# CITY OF ALBUQUERQUE

September 4, 2014

**Re: Sawmill Crossing, Grading and Drainage Plan**  
**Engineer's Stamp dated 5-23-12 (H13/D057)**

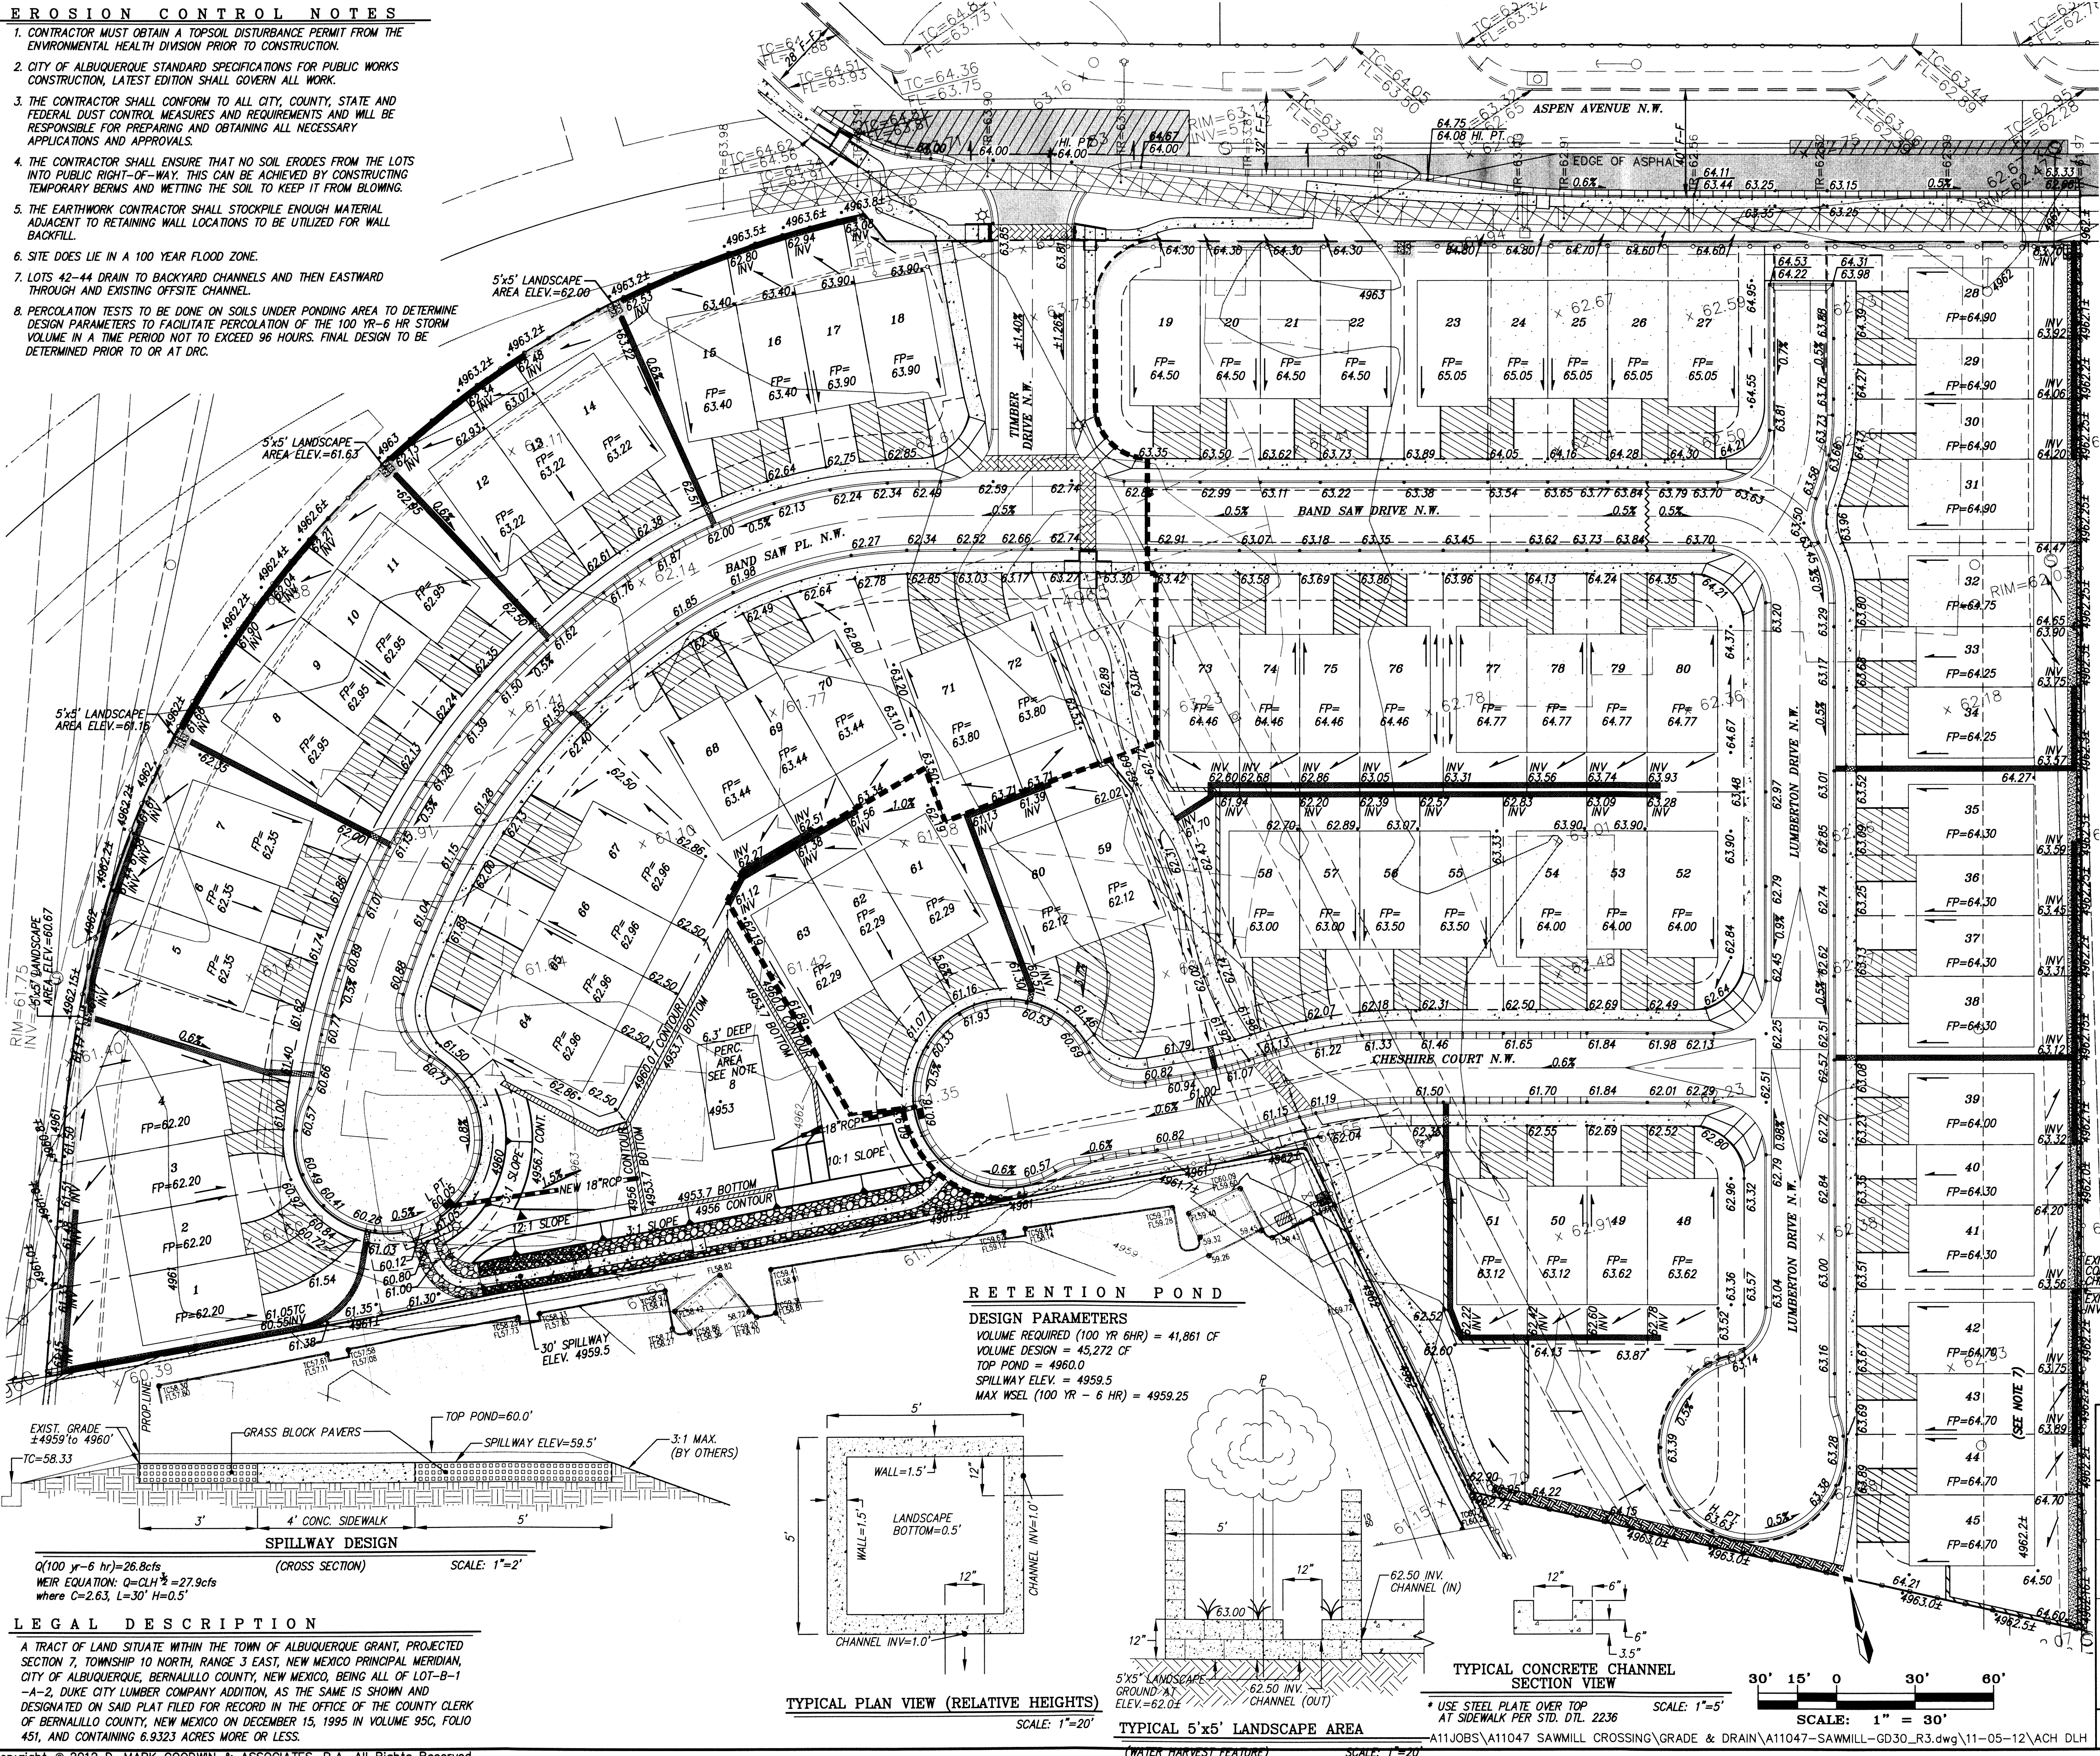
1. If the connection to the south is to be built it should be shown on the plan and how this site will tie to it.
2. Adjust grades at the west end of Cheshire Ct to reflect changes made at Unit 1 and change the plan so it does not show what was proposed but not built in Unit 1.

3. Hydrology approved a grading plan for a retaining wall along lots 19-28, stamp date 9-10-13 Mark Goodwin and Associates. TW grades are different than the spot elevations in this plan. Please review this plan and confirm the rear yard grades.

4. Provide existing grade spot elevations along around the perimeter of the site on the adjacent land.
5. The invert of the channel near Lot 58 is 61.7 upstream of the sidewalk and there is a 62.31 grade downstream of the sidewalk. This will not drain as intended. How is the water getting under the sidewalk?

6. In Unit 1, the one foot channels are to be built with the Building Permit. It is not clear how invert elevations are controlled by this process and Hydrology must put a "HOLD" on these properties for an inspection prior to Release of Certificate of Occupancy. This is a cumbersome process.

- a. The 1 foot channels in the rear yards should be built and certified prior to Building Permit approval. The side yard channels could be built with the Building Permit since the invert of the backyard channel and the sidewalk culvert at the street would have been constructed, positive drainage would have been established.

7. State how the site will manage the first flush. It drains to the pond.
8. Hydrology is having difficulty locating the drainage report submitted with Unit 1. Please provide a copy of the report with any changes as necessary.
